April 12, 2022

SUBJ: Letter of Intent, Special Use Approval

Letter of Intent_v1.pdf Markup Summary

File Name: AL-22-006

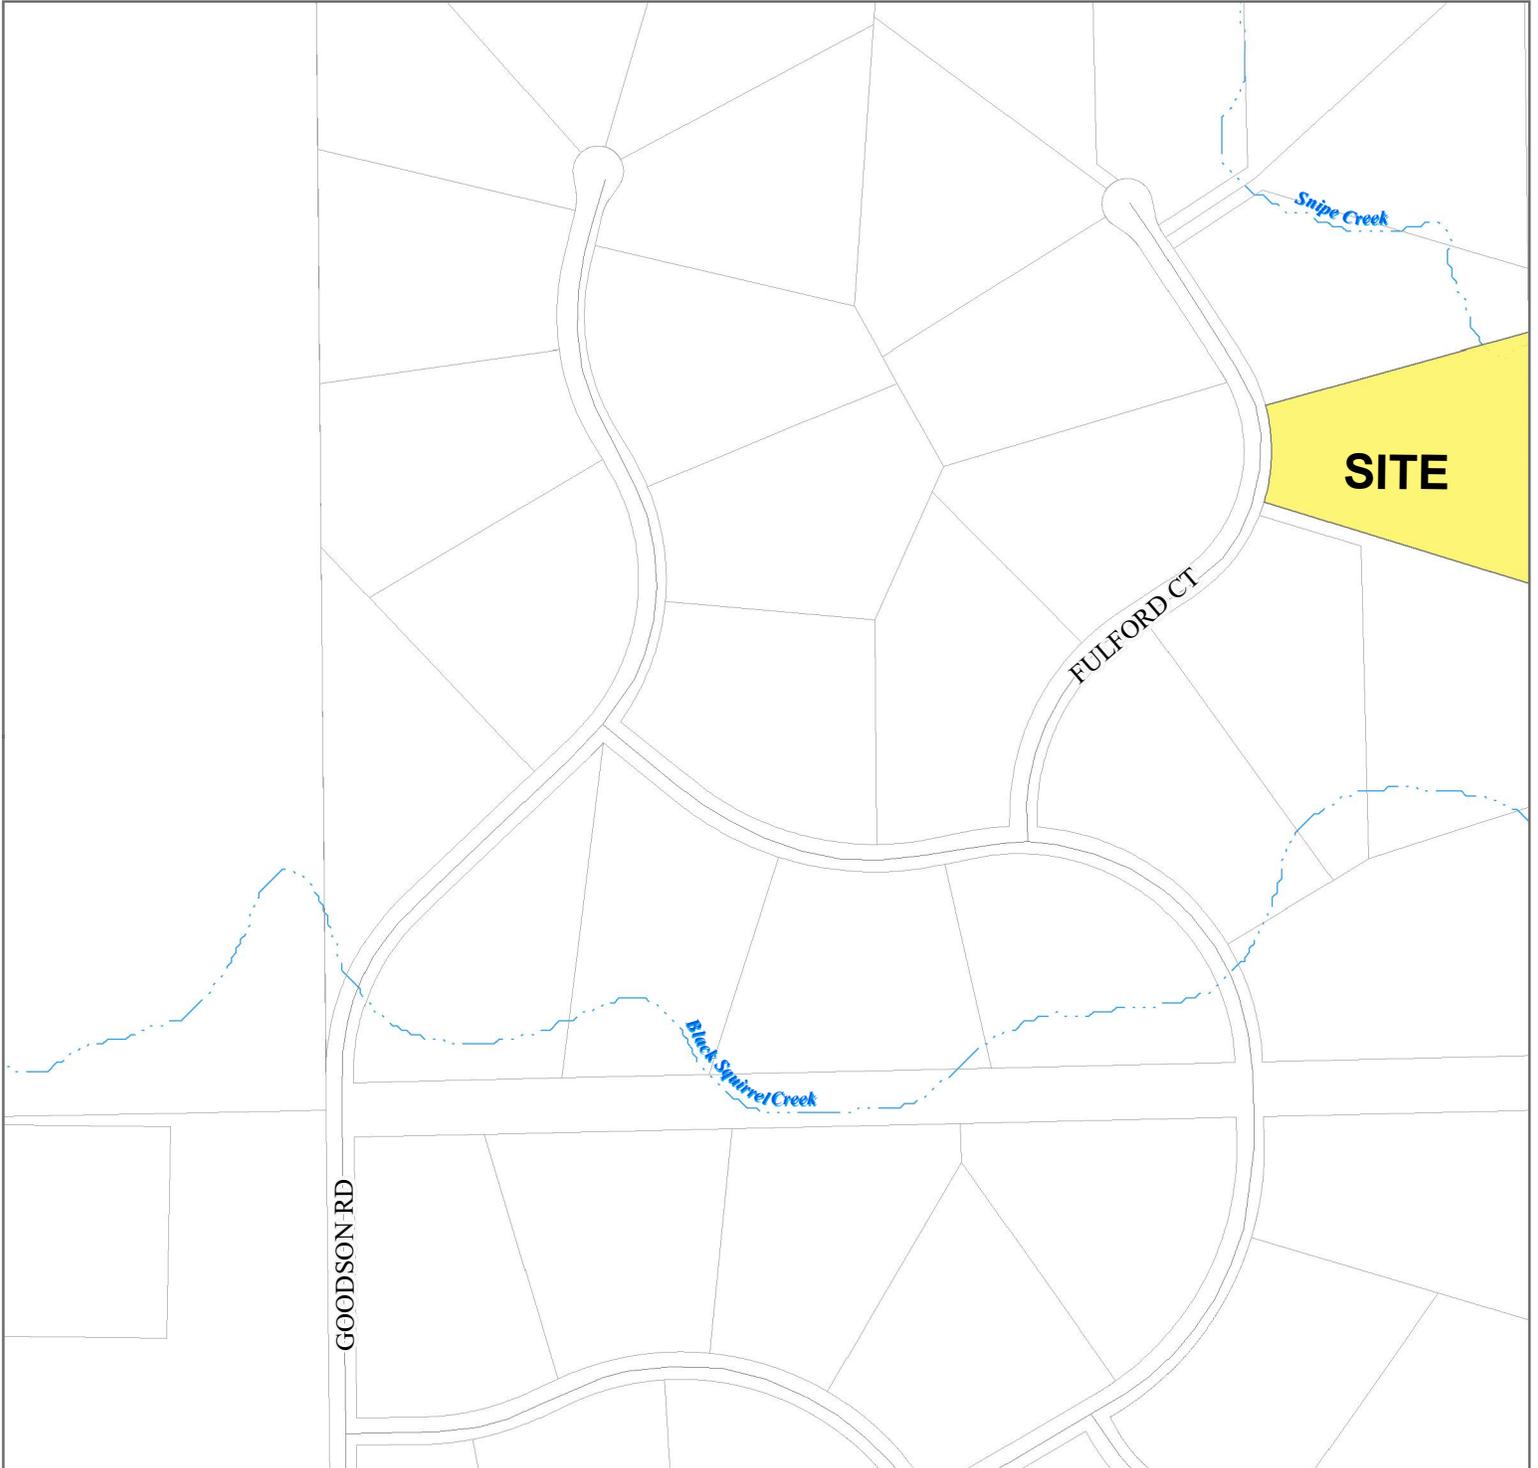
Per the plat there is a no-build area located in the north east corner of the parcel. Please confirm the proposed structure will be outside of this no-build area. Also, please provide a statement confirming the proposed structure will not adversely impact existing drainage patterns, adjacent properties, or increase runoff.
